Office of
Environment
& Heritage

DOC17/646767-1
SSD6698

Coppabella Wind Farm – Site visit outcomes

Coppabella Wind Farm - Environmental Assessment for Modification One

A3 @ 1:12500
Ref: Coppabella Wind Farm -
Final Design June 2017 Detailed
Author: TH

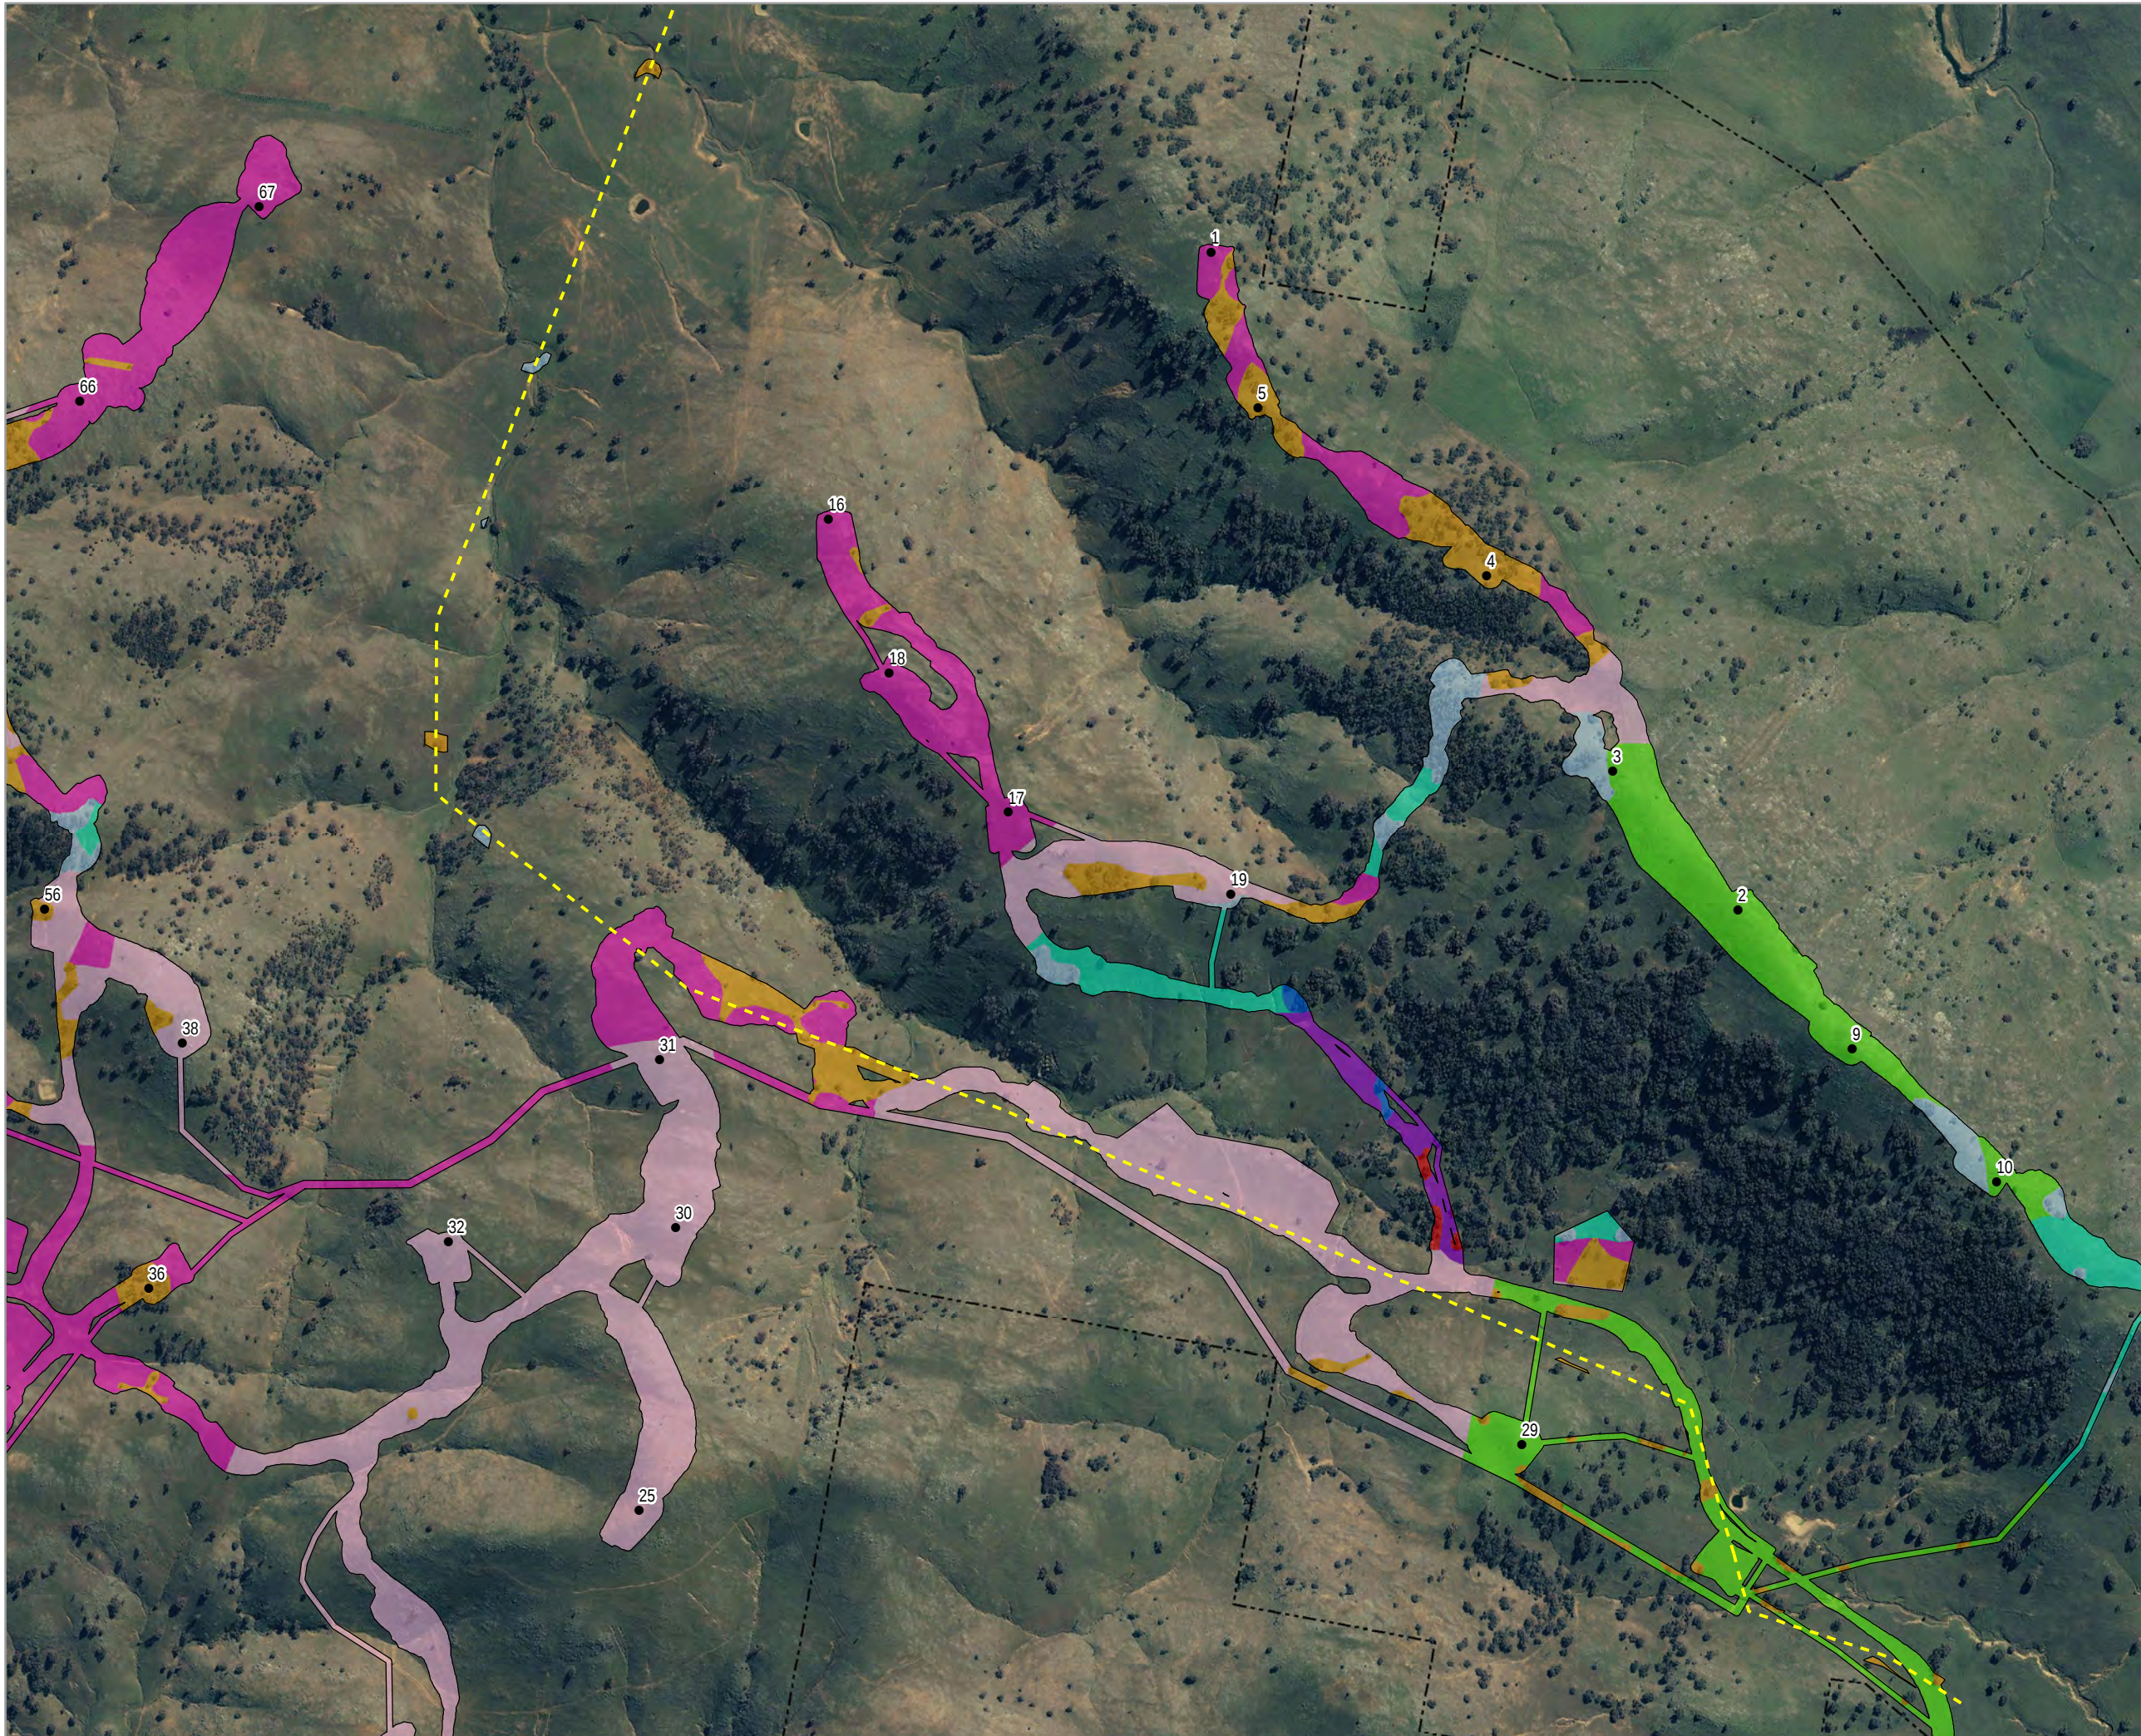
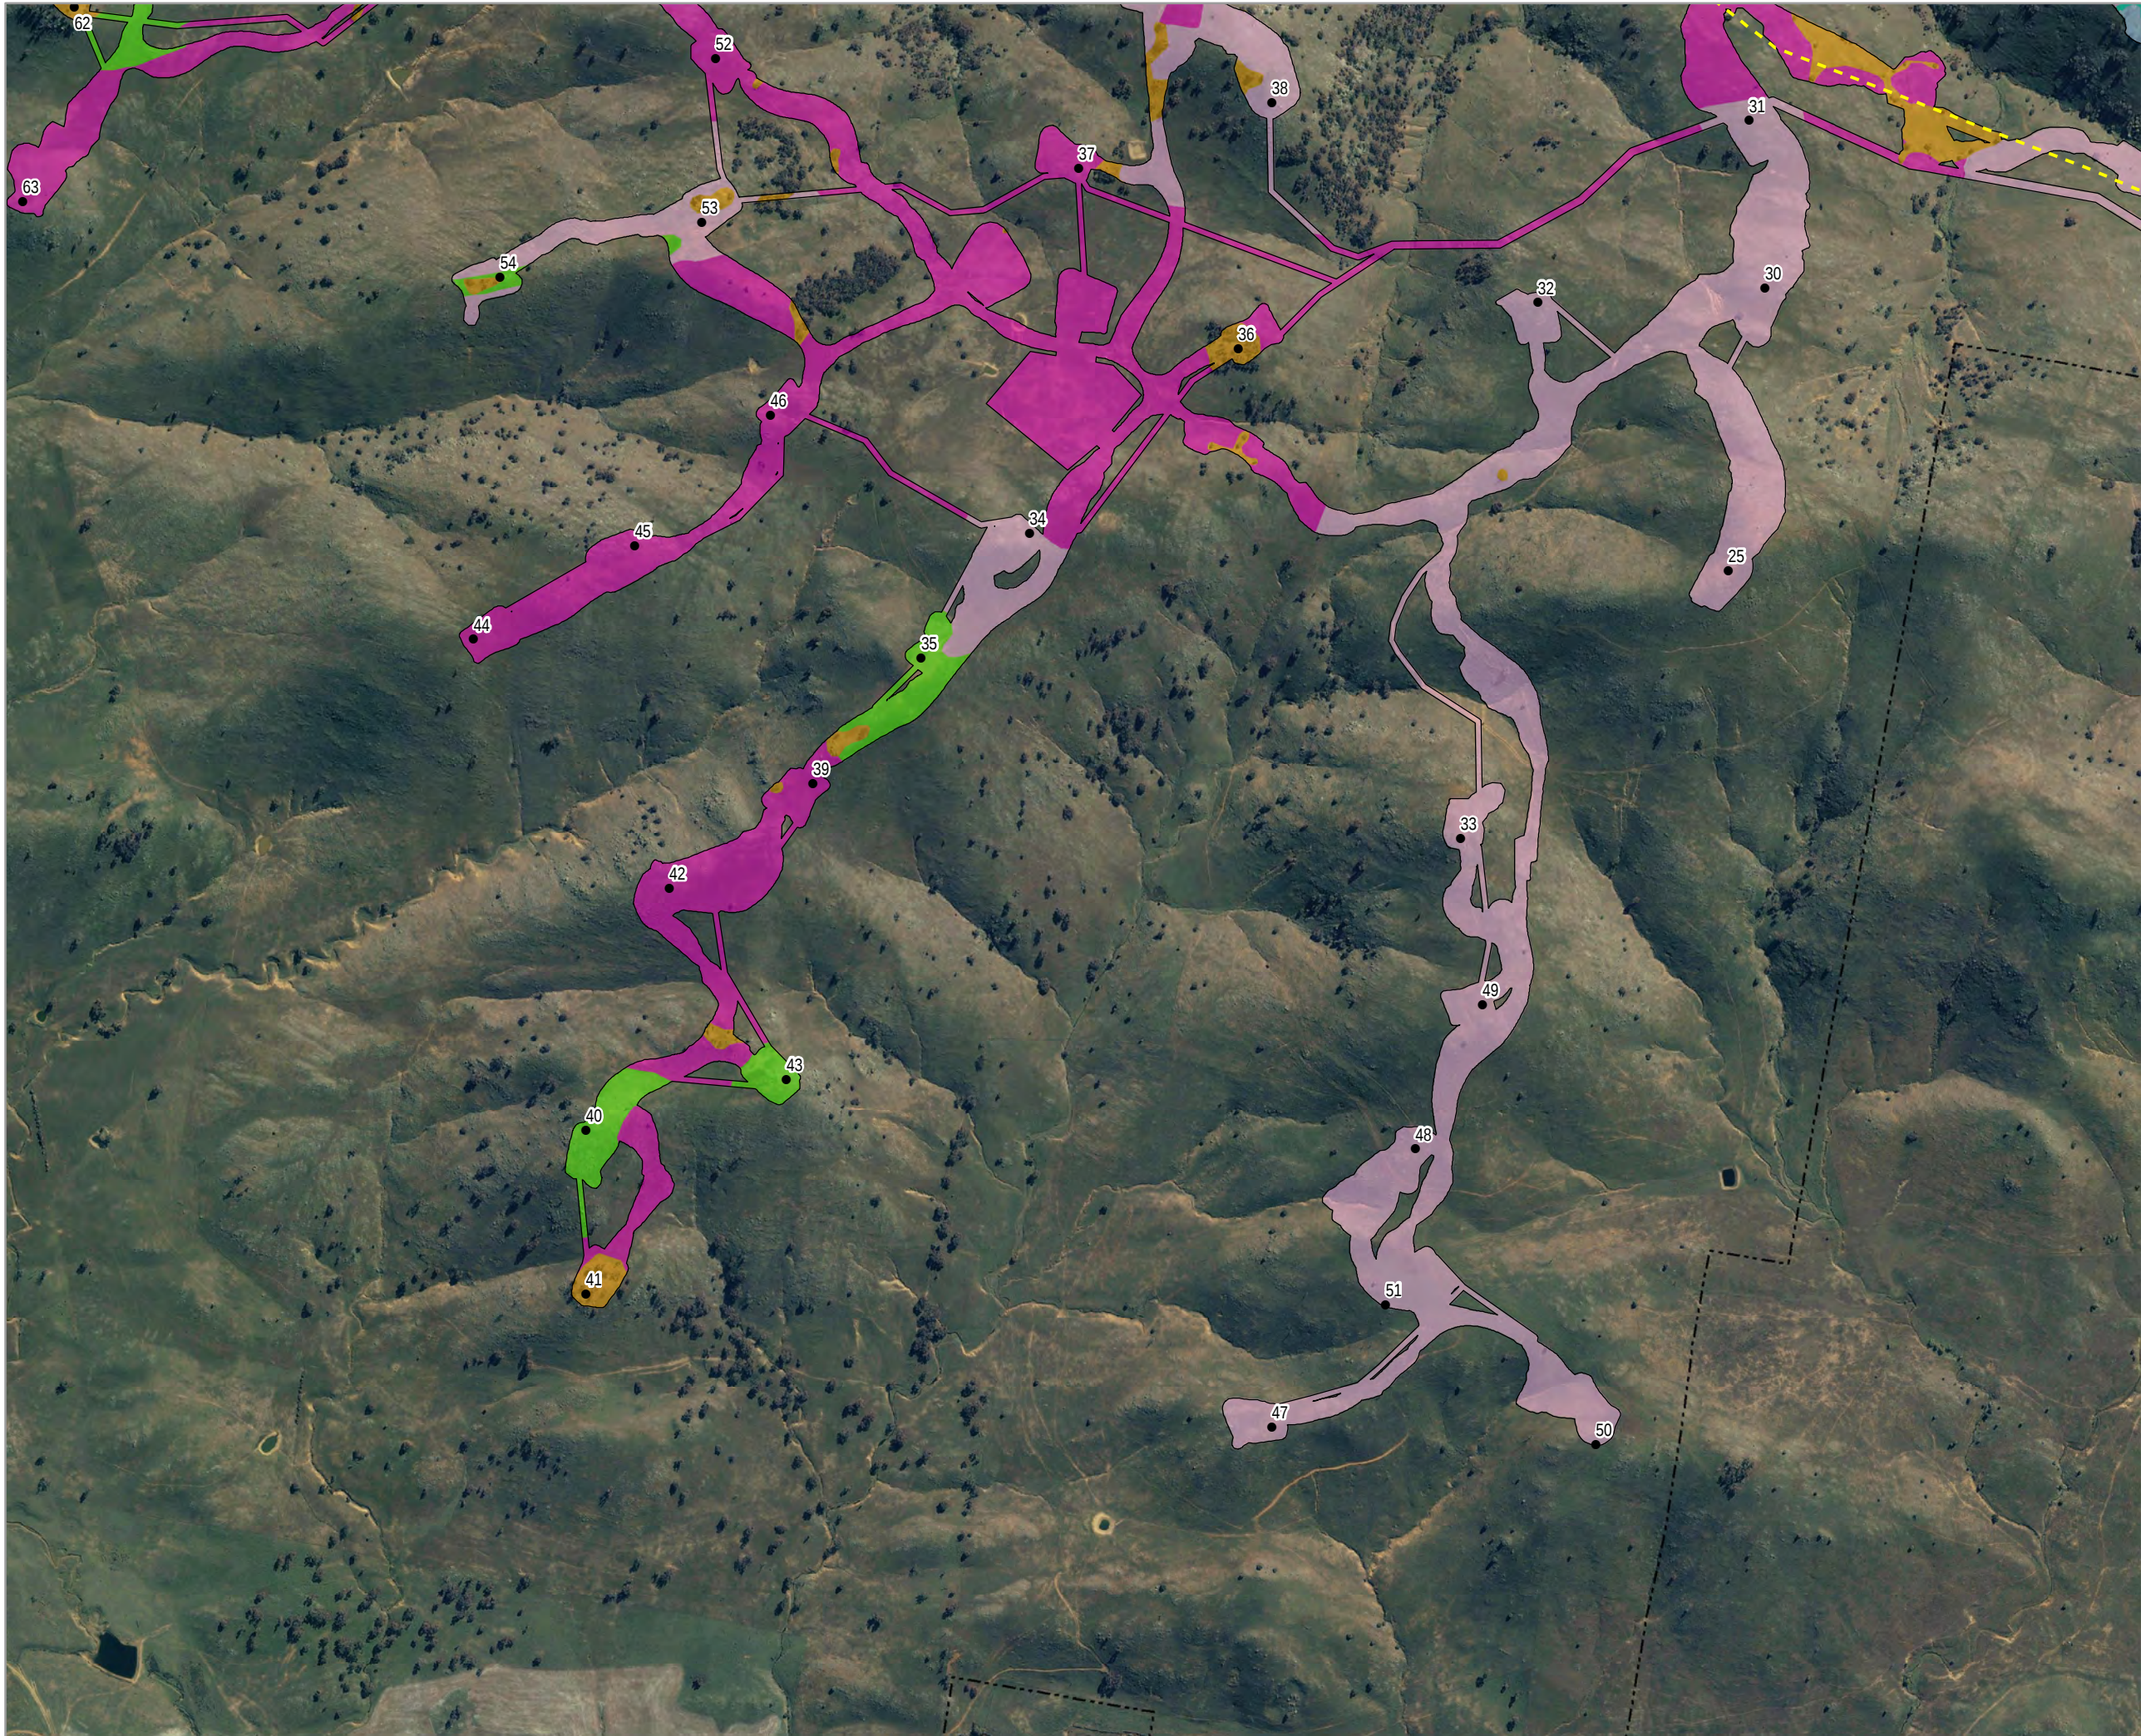
OEH's internal Reference	Easting and Northing GDA94	What the area is currently mapped as	Site inspection finding	OEH's recommended action	Map or photo reference
Photo point FID 3	643560 6151889	Exotic	Confirmed exotic.	None required	n/a
Photo point FID 4	643630 6152117	Exotic	Confirmed exotic.	None required	n/a
Photo point FID 7 – to FID 10	644242 6154023 To 644470 6153861	Exotic	This area is the Box Gum Woodland derived native grassland. NGH agreed on site.	change mapping in this area to Box Gum Woodland derived native grassland (EEC).	Area mapped on Map 1 below.
Photo point FID 13	642206 6154029	This area is mostly mapped as exotic, with small sections of Box Gum woodland - Moderate to good (low) mapped where the trees are.	The trees are close enough to mean the whole area should be mapped as the Box Gum Woodland vegetation moderate to good – the groundcover is also native (not exotic). There is a substantial Yellow Box tree with hollows in this area that should be protected during construction and operation.	Update mapping of this area to Box Gum Woodland (EEC) - moderate to good condition. Move infrastructure into the more degraded areas.	Area mapped on Map 2 below.

Photo point FID 15	641768 6154245	Exotic	Confirmed exotic.	None required	n/a
Photo point FID 16	641811 6154561	Box Gum woodland - Moderate to good (low) and mix of other.	Infrastructure placed in an area mapped Box Gum woodland - Moderate to good – when there are exotic	Suggest avoiding impact to the Box Gum woodland – EEC and situating the infrastructure in a cleared area.	Area mapped on Map 3 below.

cleared areas surrounding it.		
Observation point FID 2	641712 6154573	Exotic	Over 50% native. This area is the Box Gum Woodland derived native grassland. NGH agreed on site.	Update mapping in this area to Box Gum Woodland derived native grassland (EEC) - Moderate to good condition	Area mapped on Map 4 below.
Observation point FID 3	641685 6154576	Box Gum Woodland derived native grassland - low (exotic)	Over 50% native. Box Gum Woodland derived native grassland - Moderate to good	Update mapping in this area to Box Gum Woodland derived native grassland (EEC) - Moderate to good condition	Area mapped on Map 4 below.
Observation point FID 4	641390 6154488	Box Gum Woodland derived native grassland - low (exotic)	Over 50% native. Box Gum Woodland derived native grassland - Moderate to good	Update mapping in this area to Box Gum Woodland derived native grassland (EEC) - Moderate to good.	Area mapped on Map 5 below.

Observation point FID 5	641271 6154734	Box Gum Woodland derived native grassland - low (exotic)	Over 50% native. Box Gum Woodland derived native grassland - Moderate to good	Update mapping in this area to Box Gum Woodland derived native grassland (EEC) - Moderate to good	Area mapped on Map 6 below.
Observation point FID 6	642170 6155321	Exotic	Confirmed exotic.	None required	n/a
Observation point FID 7	640898 6155370	Box Gum woodland - Moderate to good (low)	Likely to meet a higher quality class – very good quality vegetation in this area with a very high number of tree hollows. Sighting of two Wedged-tail Eagles foraging in this area.	Avoid this area of important woodland – moving infrastructure to areas of degraded vegetation surrounding this patch.	Area mapped on Map 7 below.
Photo FID 18	636829 6155380	Exotic	Confirmed exotic.	None required	n/a
Photo FID 19 & 20	638515 6154116	Exotic	Borderline exotic and native. Difficult to tell due to grazing pressure.	None required	n/a
